From: [REDACTED]
Sent: 12 December 2018 09:00
To: Samantha Allen
Subject: RE: AW//270/18/DOC - 26 Christchurch Crescent

From: Samantha Allen <Samantha.Allen@arun.gov.uk>
Sent: Wednesday, December 5, 2018 3:45:32 PM
To: [REDACTED]
Subject: AW//270/18/DOC - 26 Christchurch Crescent

Landscaping Details – Amended 10.12.2018 (please refer to drawing submitted Oct. 2018)

Landscaping details:

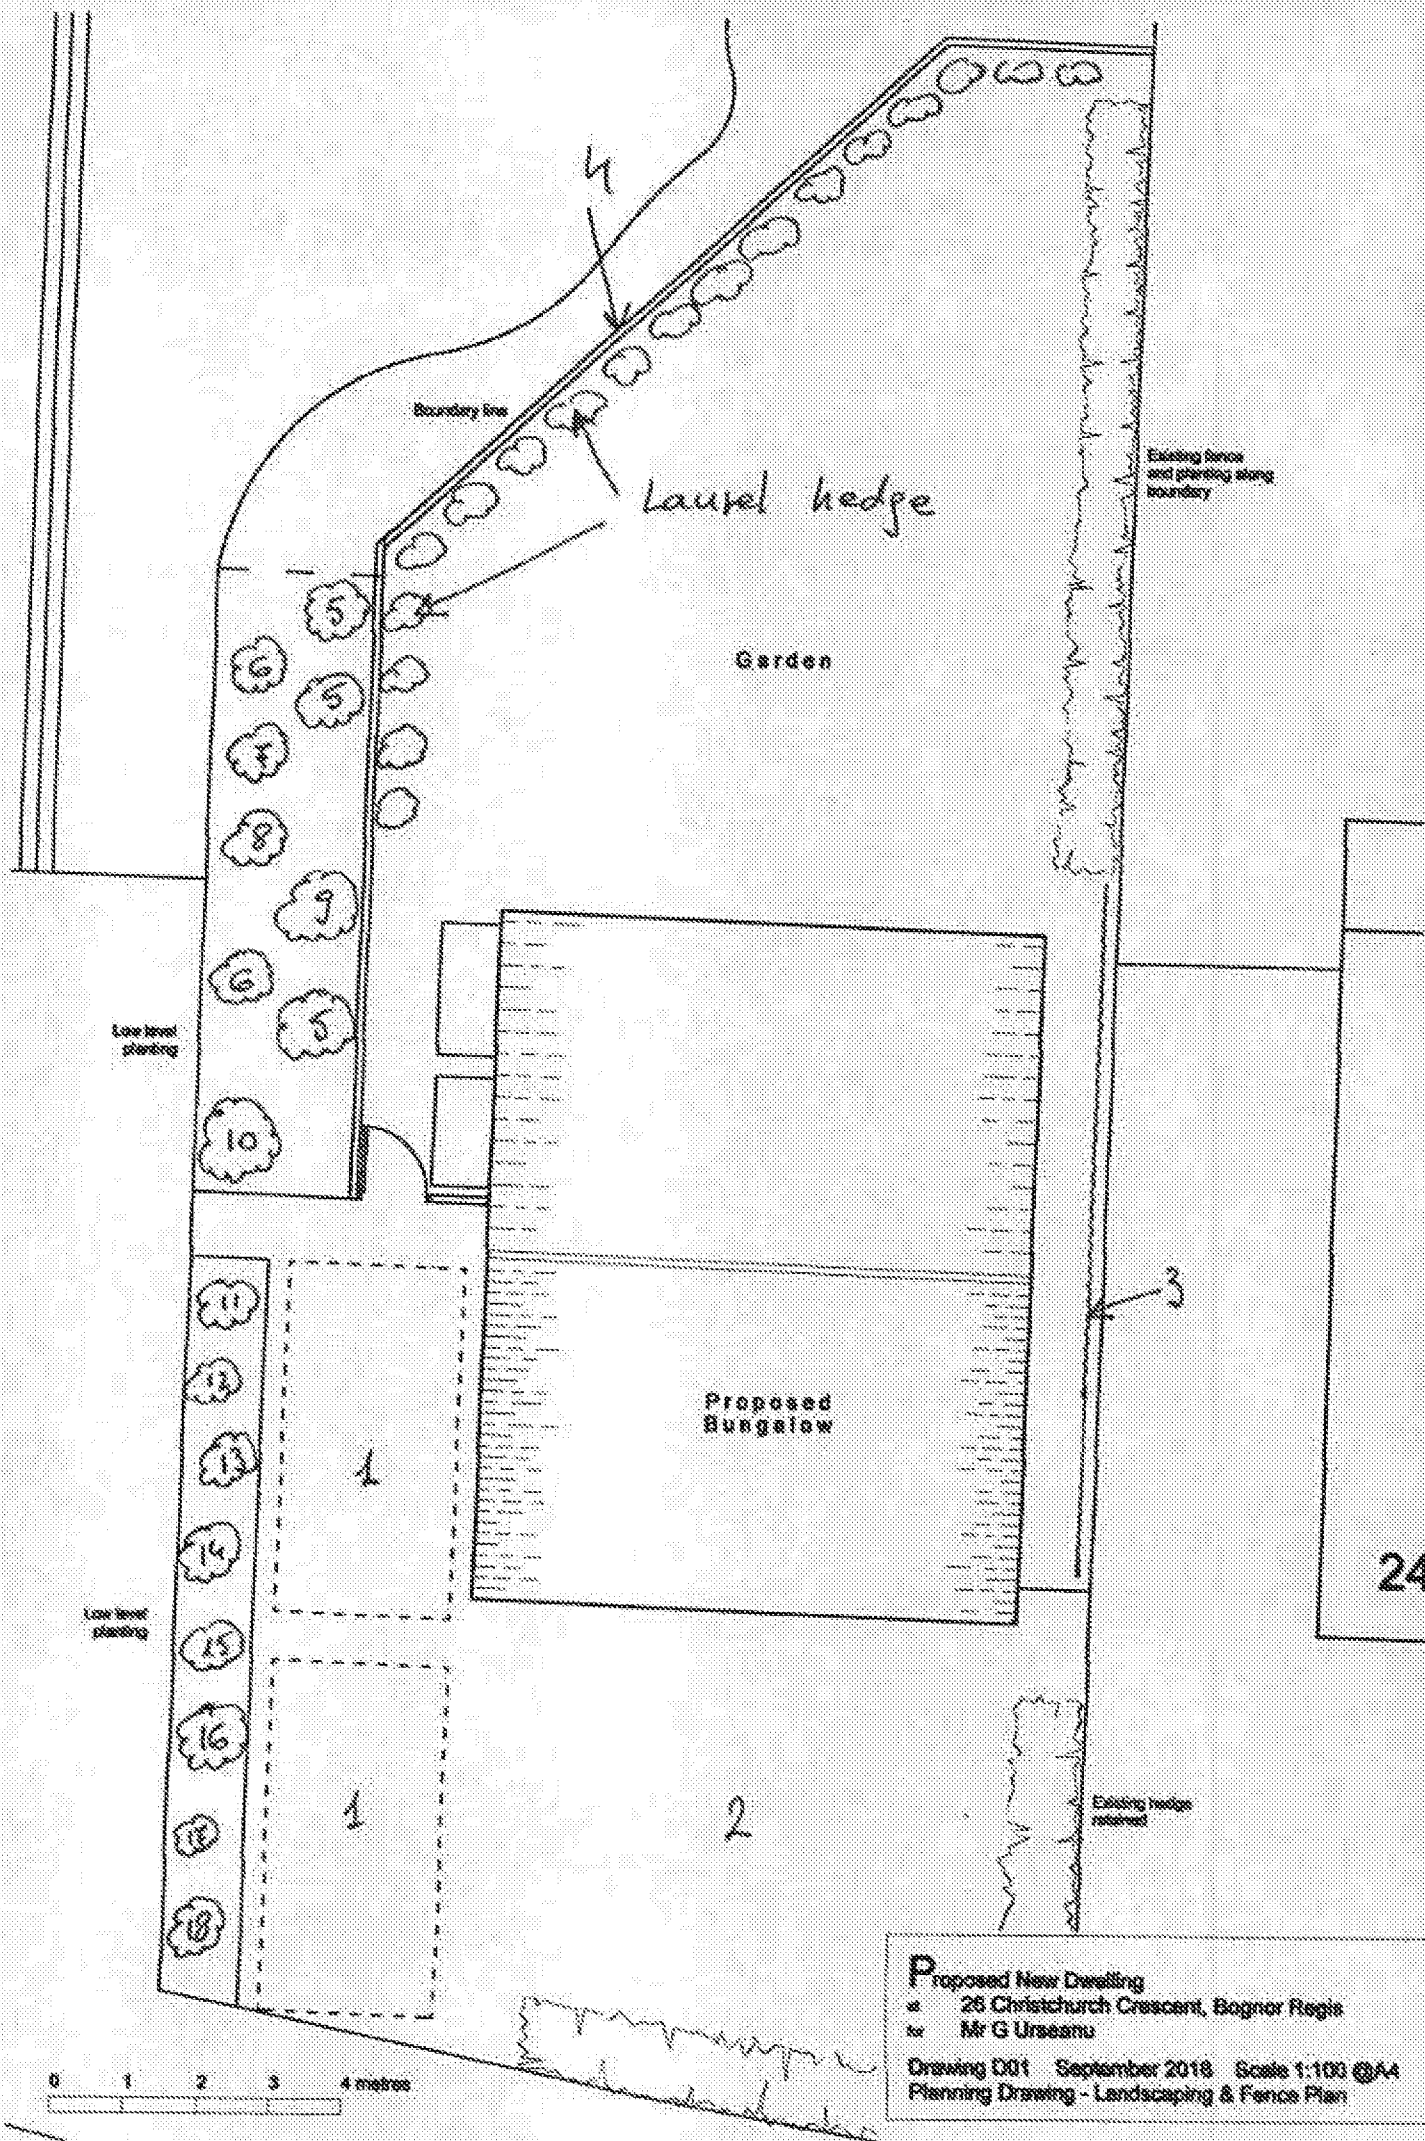
"The plant species choice detail for this location is suitable, however I still require clarification re the proposed planting with actual plant numbers, planting density and size at time of planting. This is needed for all the new planting detail and particularly required for the laurel hedge proposal."

Plants (to be planted approx. 3ft apart, allowing for retained plants, in order to achieve a soft border with a mix of textures, colours and sizes; also to allow space for annuals and bulbs)

5. one Camellia Japonica, approx. 2ft when planted
6. one Lavandula sp., ...1ft
7. one Rosmarinus officinalis.....3ft
8. one Skimmia japonica.....1ft
9. one Aucuba japonica...2ft
10. one Eleagnus x ebbingei....retained 4ft
11. one Euonymus fortunei.....2ft
12. one Buxus sempervirens..... retained 1ft
13. one Pittosporum sp.....3ft
14. one Choisya ternata ... retained 1ft
15. one Syringa vulgaris....retained 1ft
16. one Hibiscus siriacus retained 5ft
17. one Spiraea sp. retained 1ft
18. one Escallonia sp.....2ft

Laurel hedge (*Prunus laurocerasus* 'Rotundifolia') to use 3ft tall plants, planted 3ft apart, giving a total of 14 plants.
